plat _V2 redline.pdf Markup Summary 3-22-2022

BENT GRASS EAST  
COMMERCIAL FILING NO. 3  
JOB NO. 2177.64  
NOVEMBER 30, 2021  
SHEET 1 OF 2

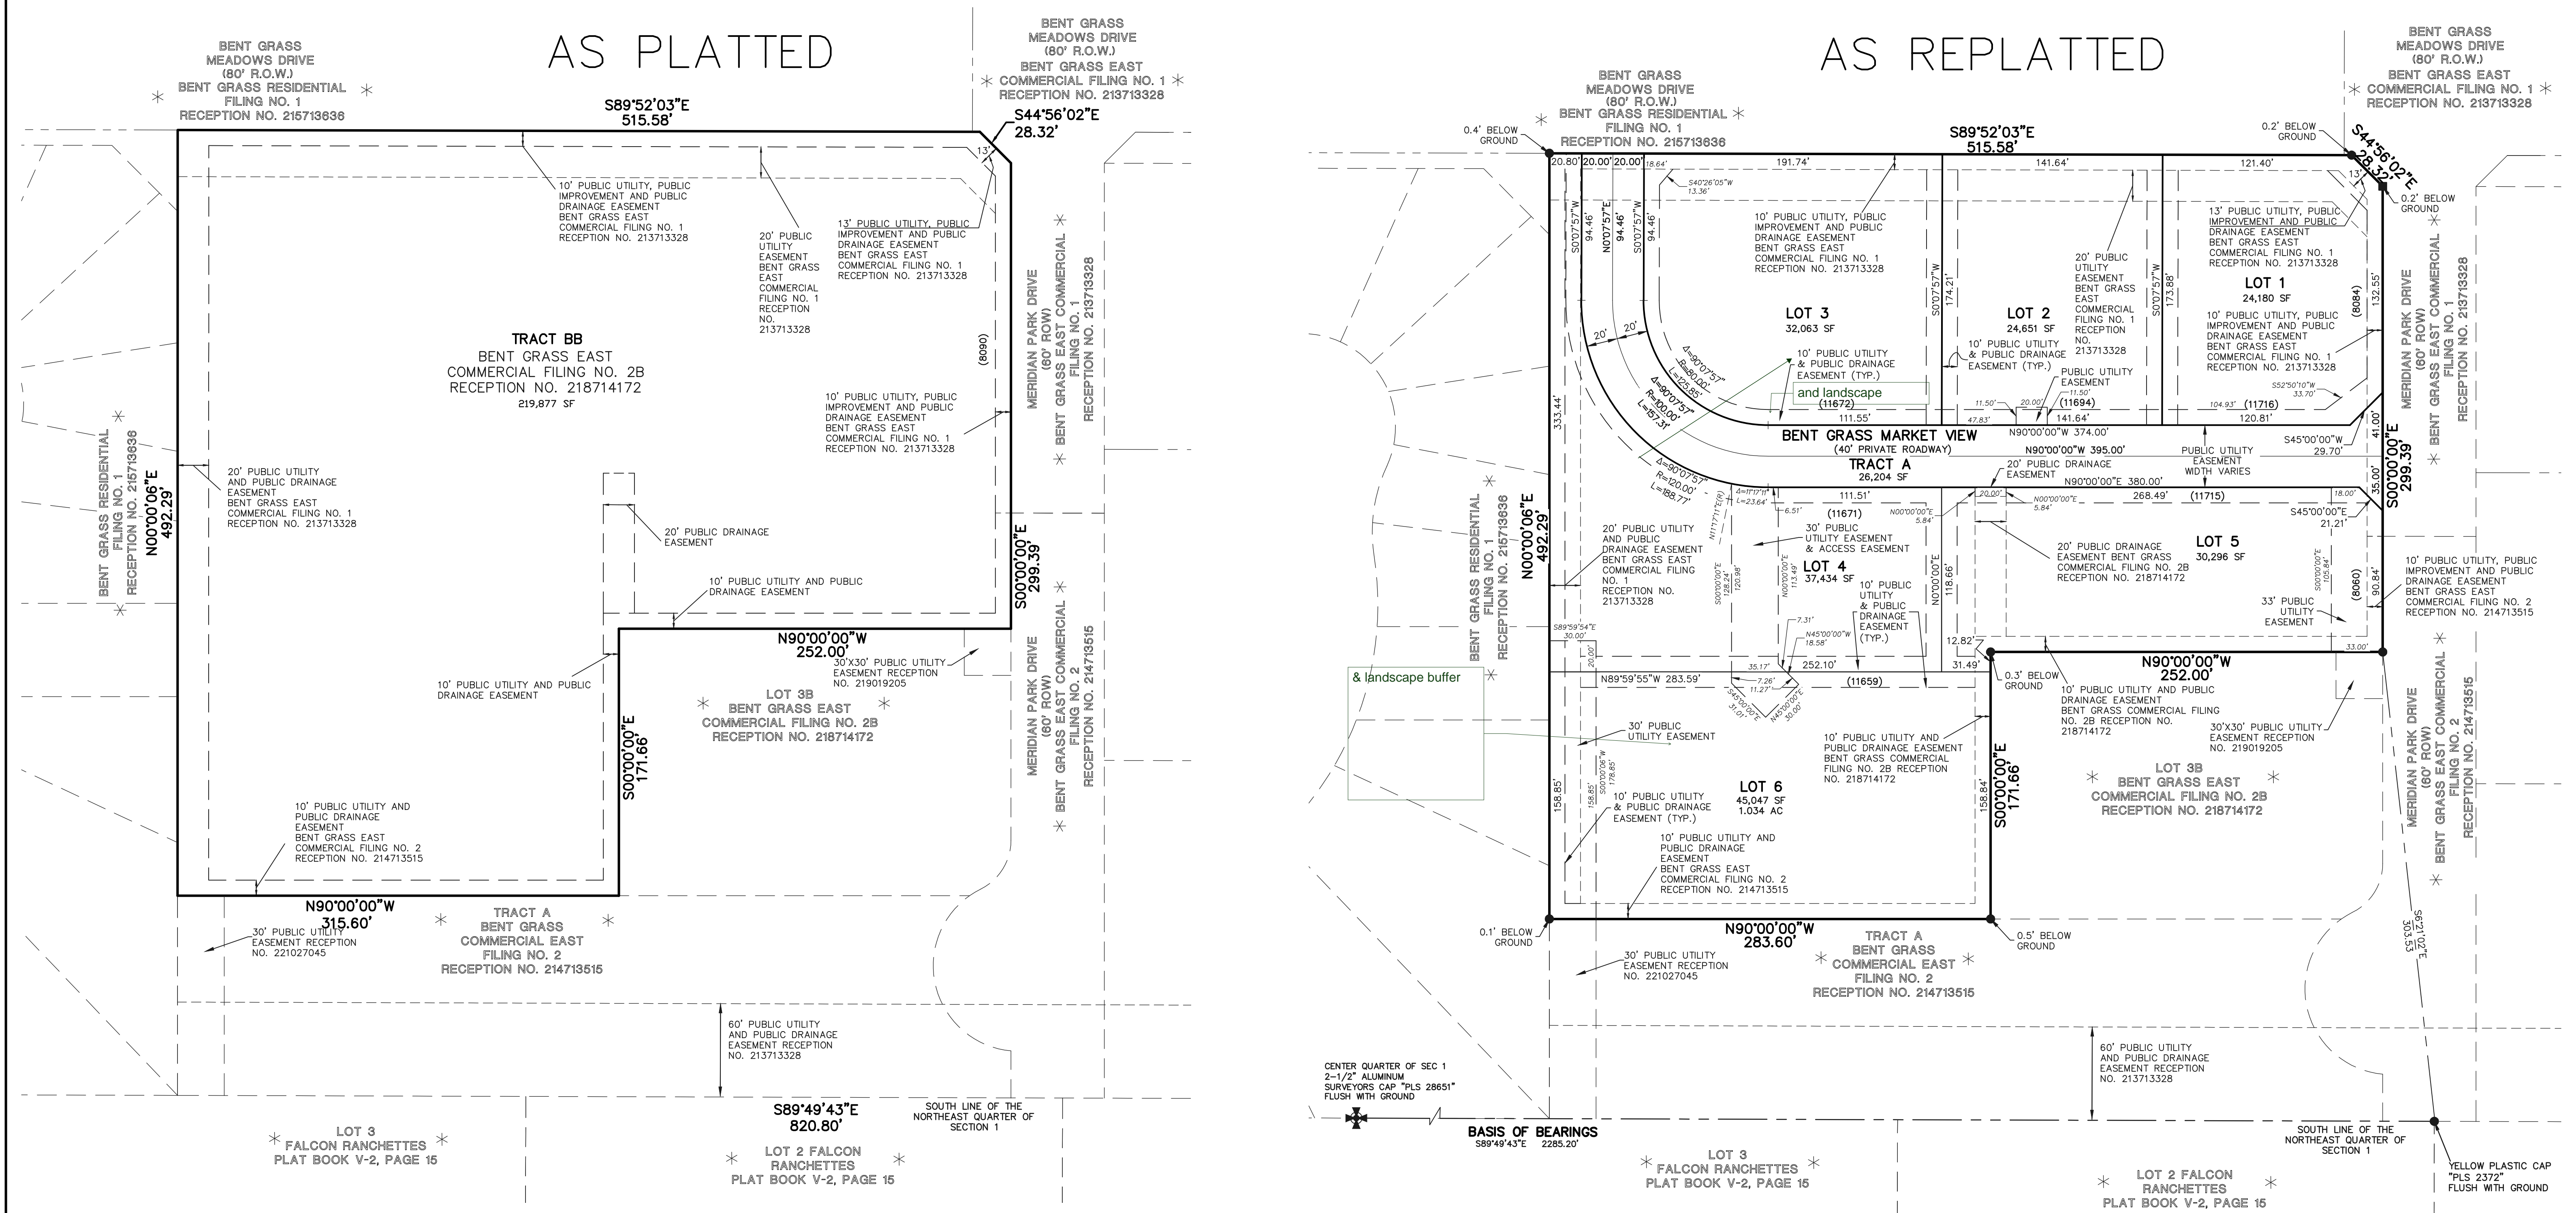
Please add the note regarding maintenance of the westerly opaque fence and landscape along private and public roads and western boundary to page 1 plat notes.

**ADDED FENCING TO
NOTE 30.**
